From: Breezie Allwright on behalf of Planning.Responses
Sent: 02 December 2025 11:40
To: Planning Scanning
Subject: FW: Planning Application Number: BR/200/25/HH

I am writing to formally object to the planning application for a double garage and home office at 186 Aldwick Road (Application Number: BR/200/25/HH).

Block Plan

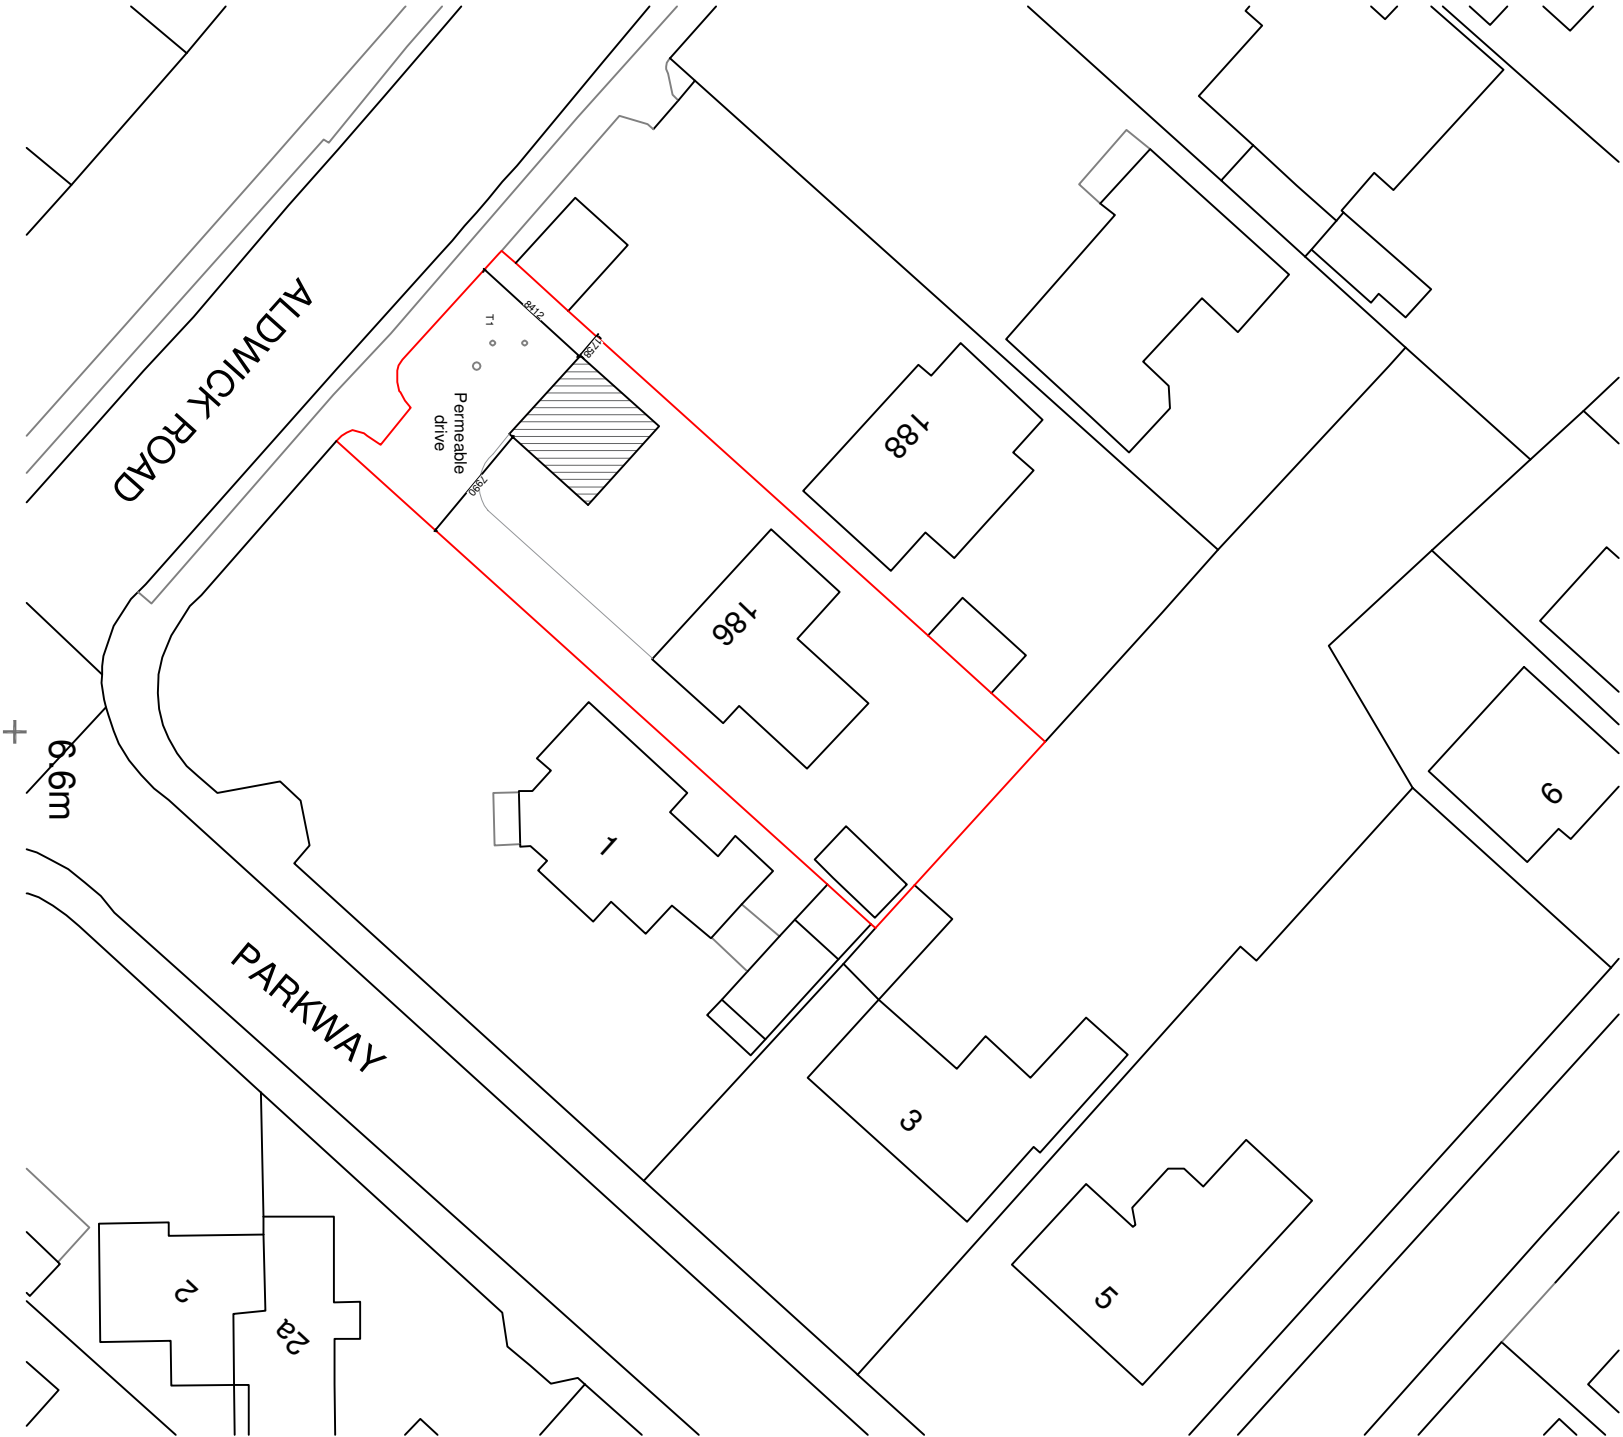
Any new development should respect local character and contribute positively to the streetscape. The proposed garage and office, positioned in front of the property, are significantly oversized and highly visible—out of keeping with Aldwick Road’s character of open frontages and properties set well back from the street.

The addition of a large hard-surfaced driveway—tight for manoeuvring and parking into two garage spaces—would intensify activity and diminish the area’s tranquillity, undermining the peaceful residential nature that residents value. **Based on the submitted plans, I do not believe there is sufficient space to safely turn and park vehicles within the site, which could result in vehicles reversing onto Aldwick Road, increasing highway safety concerns.**

The proposed oversized garage and office at the front of the existing house and garage encroaches on the established building line, disrupting the rhythm of properties set back with open front gardens.
